Harnett County

Permit Number: BCOM2603-0008

Description: Auto Retail Shop & Unpermitted 12x16 Prefab Storage Building

# SLOANS AUTO SALES

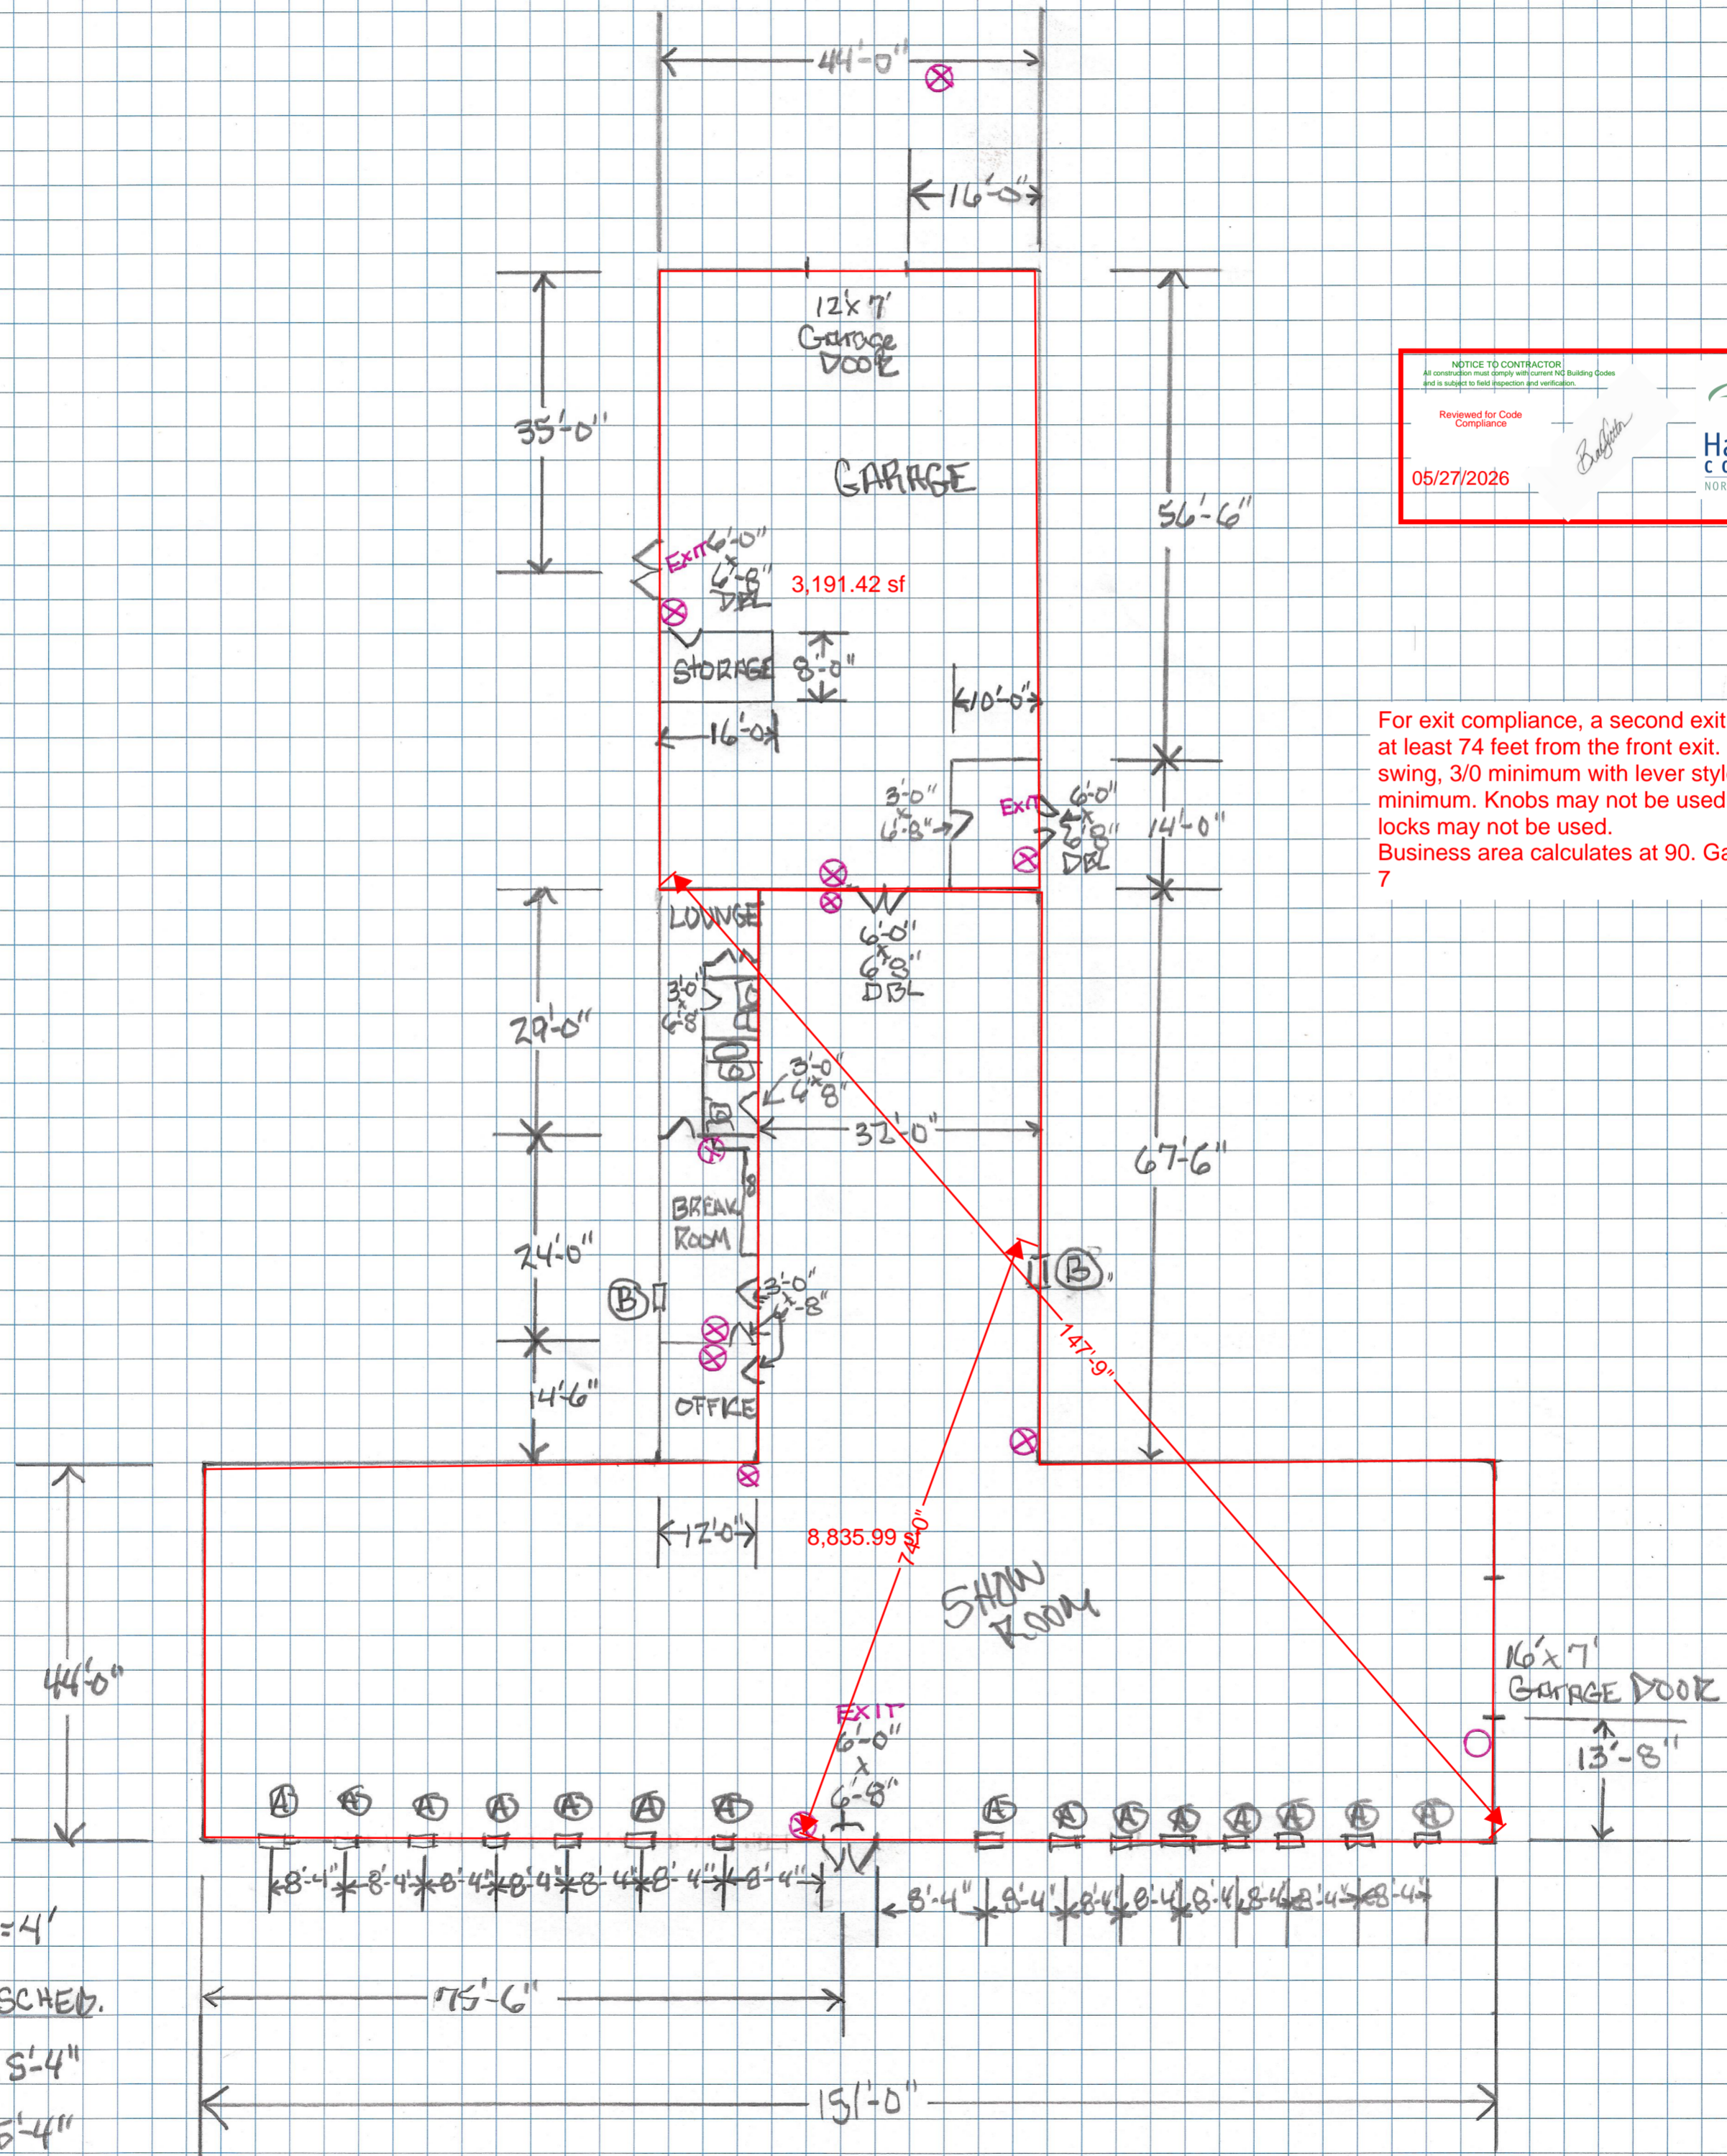
SEQ ID	SCHEDULED DATE	COMPLETED DATE	TYPE	INSPECTOR	RESULT	REMARKS
40	5/29/2026	5/29/2026	ZONING	Randy Baker	APPROVED	
Notes: Site development improvements have been completed.						
40	6/10/2026 AM	6/10/2026	FM FINAL	Roger Sullivan	APPROVED W/EXC	see notes
Notes: Remove flush bolts from both exit doors in garage area. Repair landing on outside of right rear garage exit door. Install exit sign over new exit door in showroom. Front access gate needs a knox box key entry system installed on it.						
40	6/11/2026 PM	6/11/2026	FM FINAL	Roger Sullivan	APPROVED	Approved
Notes: Final inspection, all passed.						
50	6/15/2026	6/15/2026	FINAL**	Steven Gazlay	DISAPPROVED	
Notes: Secure storage building at each corner with mobile home style anchors. Need labeling at front door.						
50	6/22/2026	6/22/2026	FINAL**	Steven Gazlay	APPROVED	
Notes:
